16 May 2022  
L 220516 NS RB Covering letter and Addendum Planning Statement FINAL

**Section 73 Town and Country Planning Act 1990**  
**Application to Vary Conditions 2 and 4 and Remove Condition 8 of Full Planning Permission Ref. 21/02366/F relating to land at Wincote, Cow Lane, Steeple Aston, OX25 4SG**  
**On behalf of Mr. Henry Squire**  
**Planning Portal Reference: PP-11254666**

## ADDENDUM PLANNING STATEMENT

Drawn	Date	Scale @ ISO A1	Job Number
DOL	21/06/21	1:100	20064
Drawing Number	Revision		
20064-SQP-ZZ-ZZ-DR-A-PL221	P3

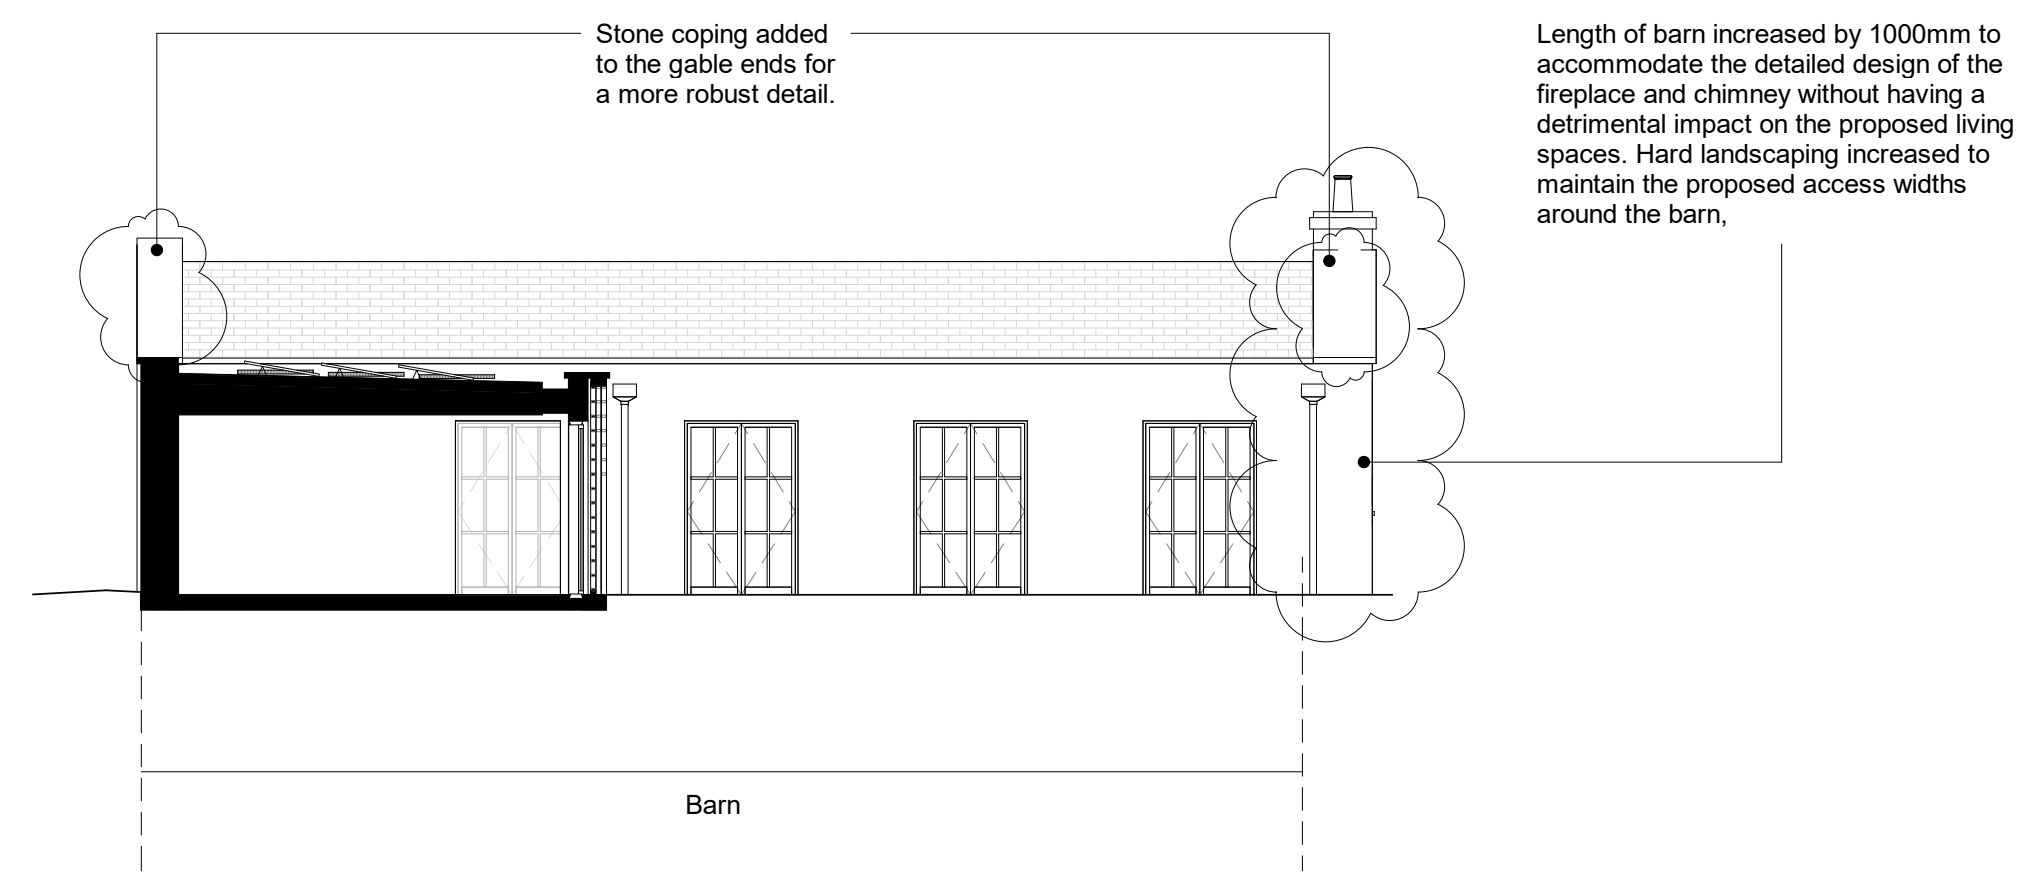
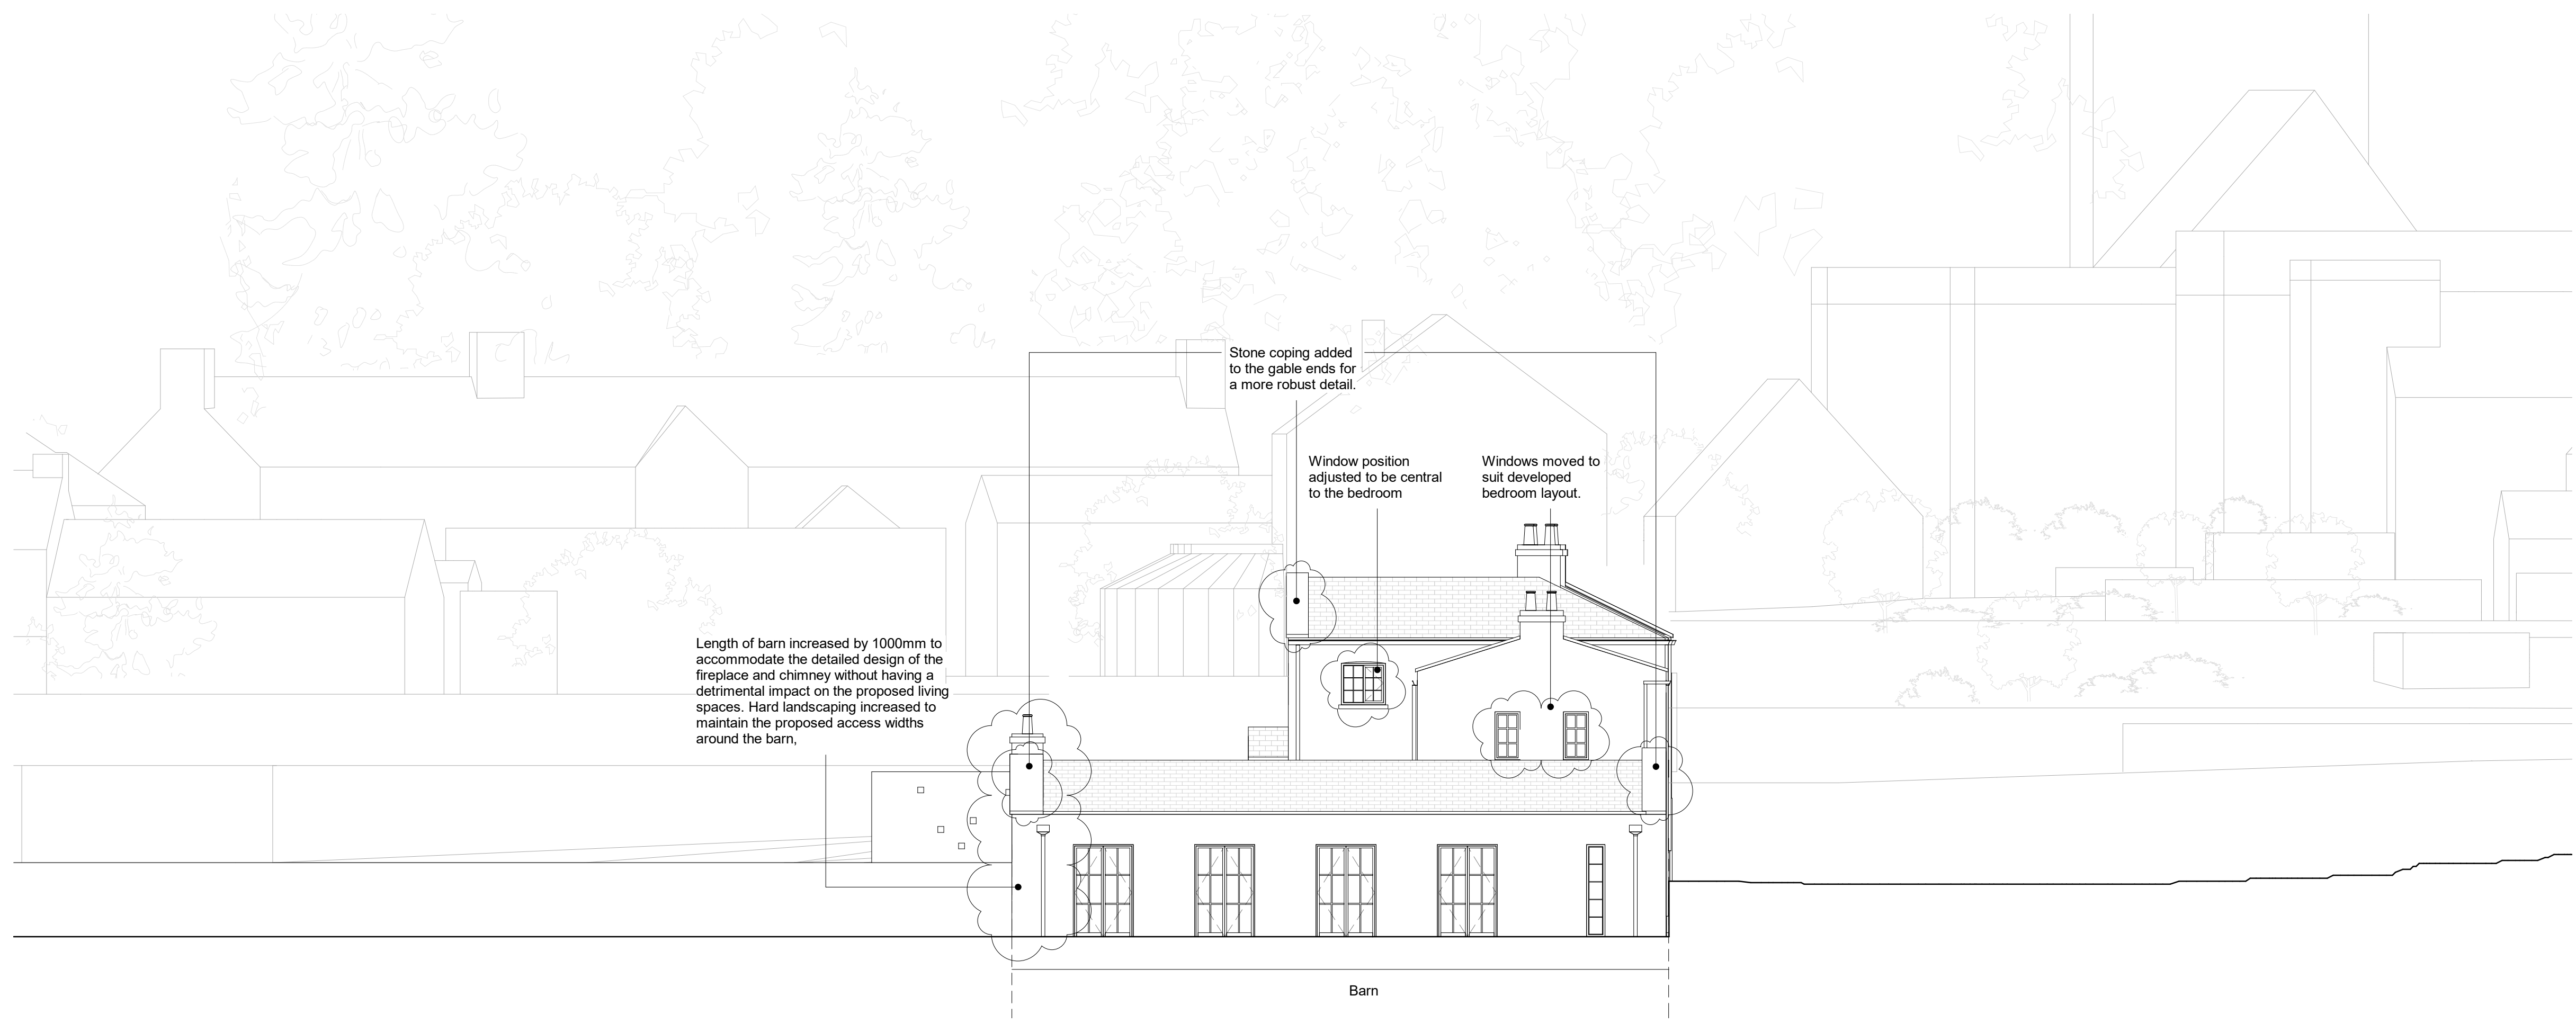
- Barn increased in length by 1m to accommodate the detailed design of the fireplace and chimney without having a detrimental impact on the consented living spaces.

- Width of the barn terrace has increased by 800mm to accommodate a stair, ensuring that connection to the east area of the garden is retained.
- Layout of spaces along the east wing ground floor corridor have been revised to provide increased storage, better connectivity to the first floor master bedroom and a more usable living space.

- Windows to the north and east facades to match style of the rest of the property.
- Bedroom windows above the entrance hall have been moved to sit centrally to the bedroom, windows at ground have also moved to maintain the alignment.

- Windows of the ground floor en-suite have enlarged for improved natural light into the space.
- Windows on the east façade of the master bedroom have shifted positions to better suit the developed bedroom layout.
